From: [REDACTED]
Sent: 19 November 2013 10:10
To: 'Wayne Gander'
Subject: RE: Howard House, Pevensey Road, Bognor Regis

Following our telephone conversation I am pleased to attach an amended drawing for this site. The changes are of a relatively minor nature but I attach drawings for your attention anyway. They are;

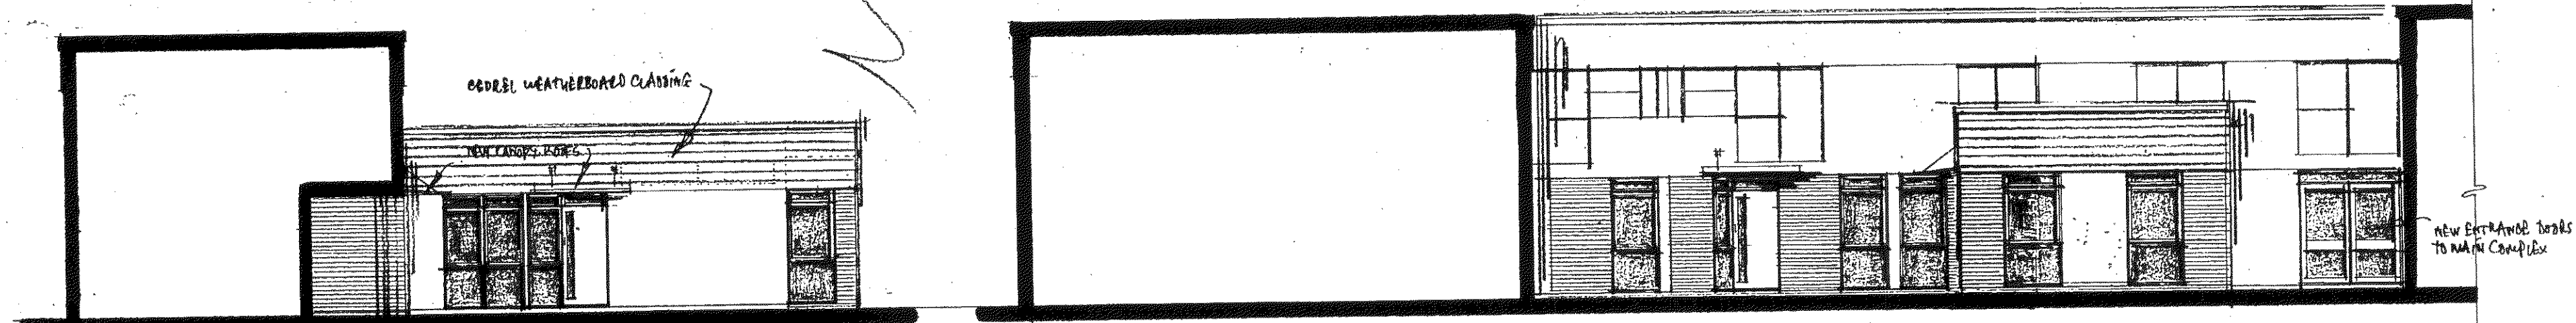
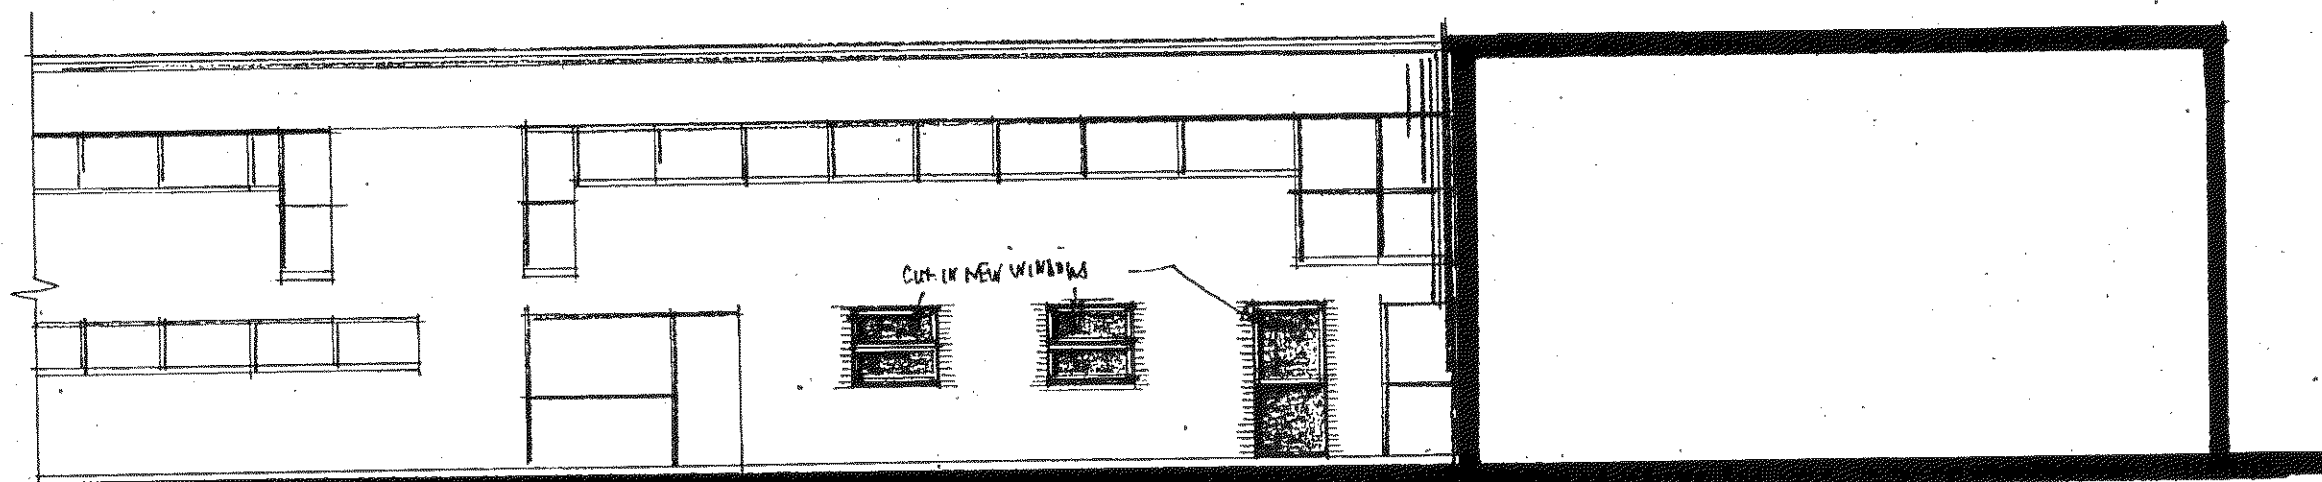
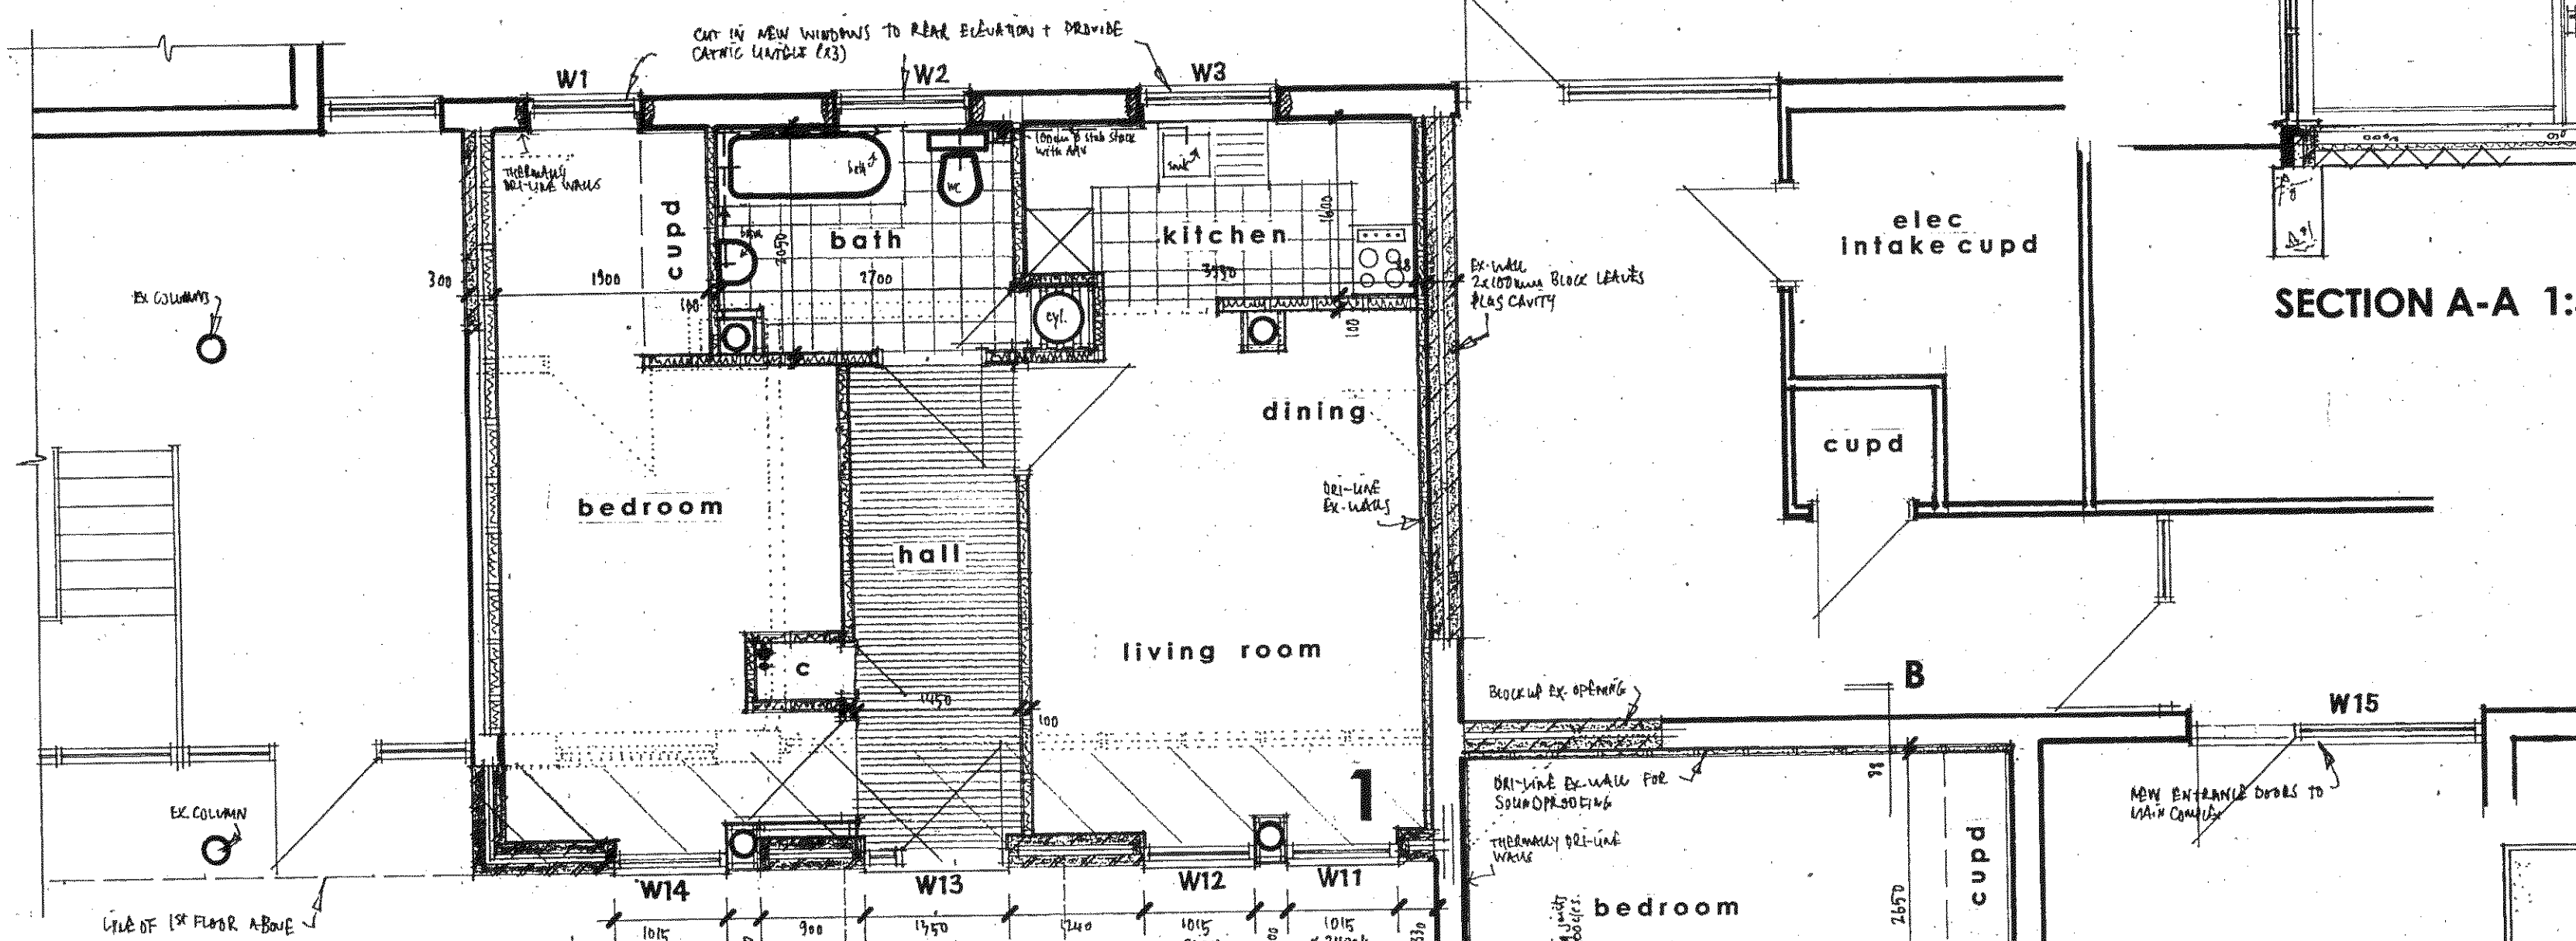
1. Change of materials. The upper render panels will now be Cedral Weatherboard cladding.
2. The curved brickwork has been changed to square edged.
3. The internal layouts have been adjusted to suit building control requirements.
